RE: PROJECT – PRELIMINARY PLAT - PR-2025-020092, VOLCANO CLIFFS UNIT 26

Please find below the verbatim review comments received as part of the Sketch Plat process for the above-referenced project. Each comment is grouped by reviewing department and is followed by a placeholder for the applicant's response. The Sketch Plat meeting was held on 8-6-25.

Compiled Sketch Plat Review Comments with Applicant Responses

CSI-CARTESIAN SURVEYS INC.
P.O. BOX 44414 RIO RANCHO, N.M. 87174
Phone (505) 896 - 3050 Fax (505) 891 - 0244
cartesianbrian@gmail.com
Sheet 2 of 4
251082

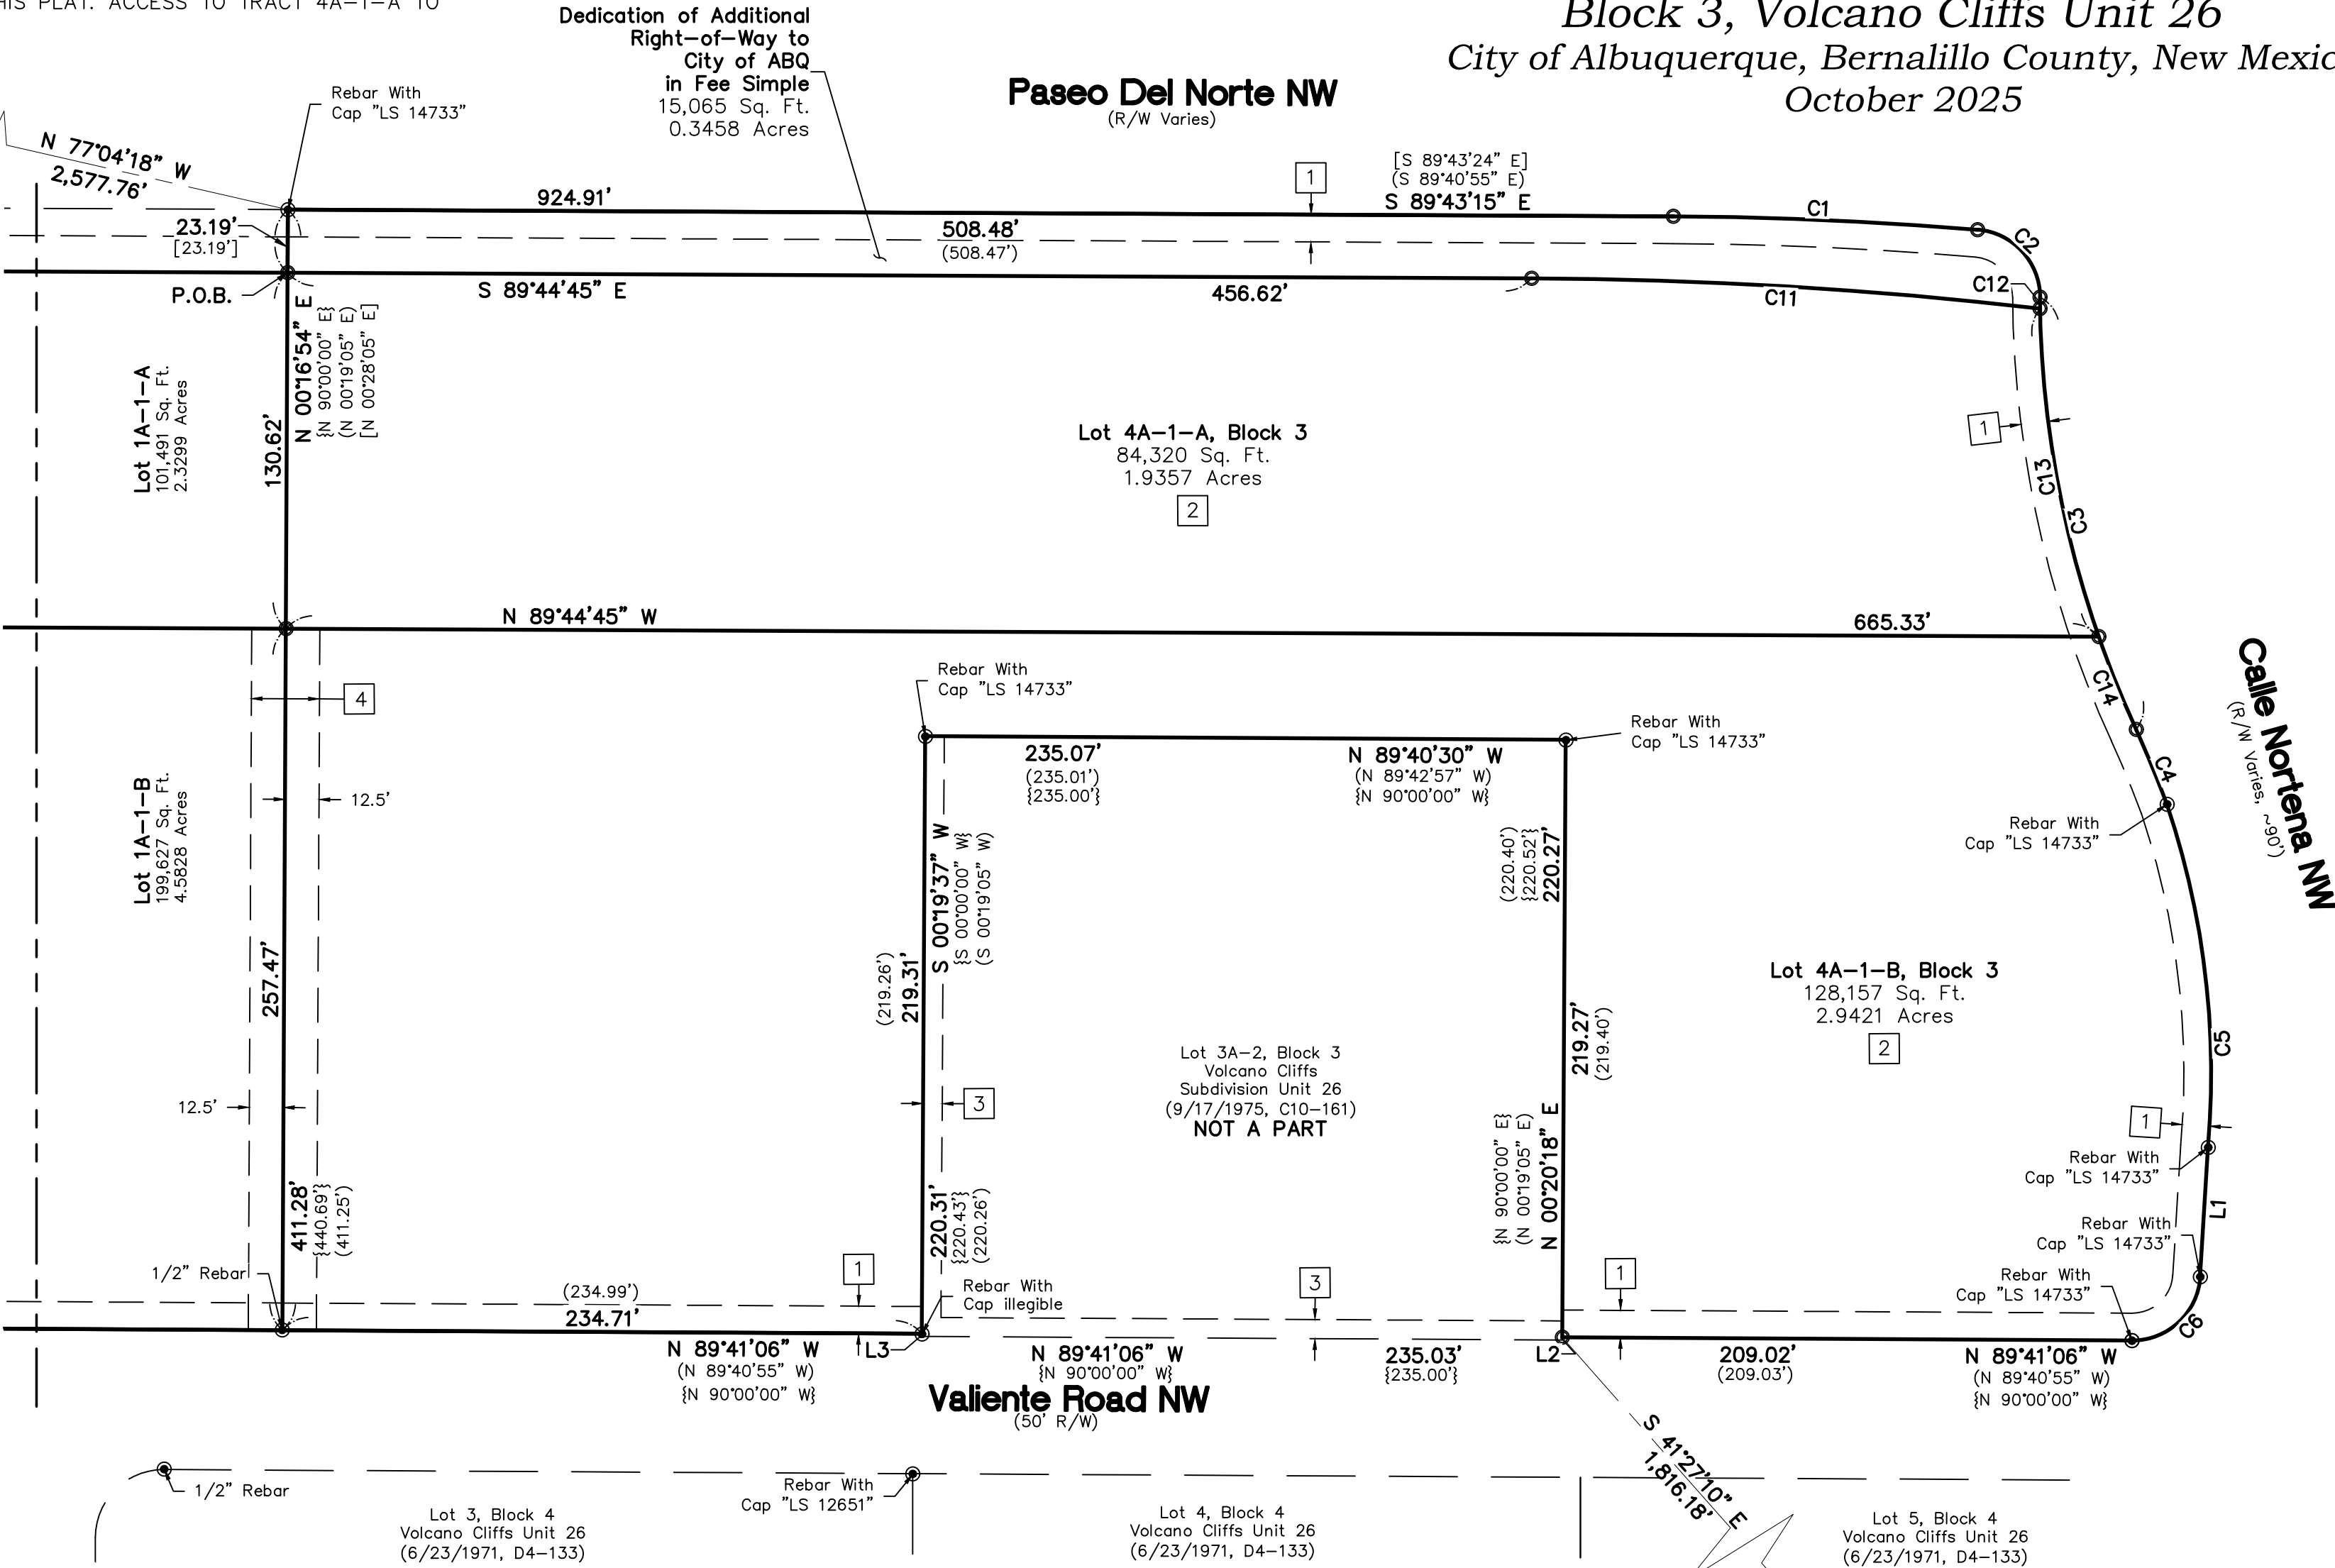
- Comment: As proposed, Lots 4A1A and 1A1A do not have all frontages with access to both water and sanitary sewer infrastructure.

- Comment: Exclusive public water and sanitary sewer easements are required for all public lines that are to be constructed outside of any dedicated rights-of-way. A minimum width easement of 20' is required for a single utility and 25' for water and sewer both within the same easement.

- Comment: The surveyor shall field verify the location of existing private water and/or private sanitary sewer services to determine if private service easements are needed.

- Comment: Proper private water and/or private sanitary sewer service easements shall be granted for access to public waterline and/or public sanitary sewer for proposed lots which do not have direct access.

Applicant Response: 4A-1-A will access water and sewer from Calle Norte road. 1A-1-A will access sewer from the new proposed 20' private sewer easement (Easement 4 on the plat). Water will be accessed off of Kimmick Road. Please see conceptual Utility plan for reference.

Applicant Response: A new proposed 20' private sewer easement (Easement 4 on the plat) will be granted with this plat.

Applicant Response: Completed and a new proposed 20' private sewer easement (Easement 4 on the plat) is being proposed on this plat.

Applicant Response: 4A-1-A will access water and sewer from Calle Norte road. 1A-1-A will access sewer from the new proposed 20' private sewer easement (Easement 4 on the plat). Water will be accessed off of Kimmick Road. Please see conceptual Utility plan for reference.
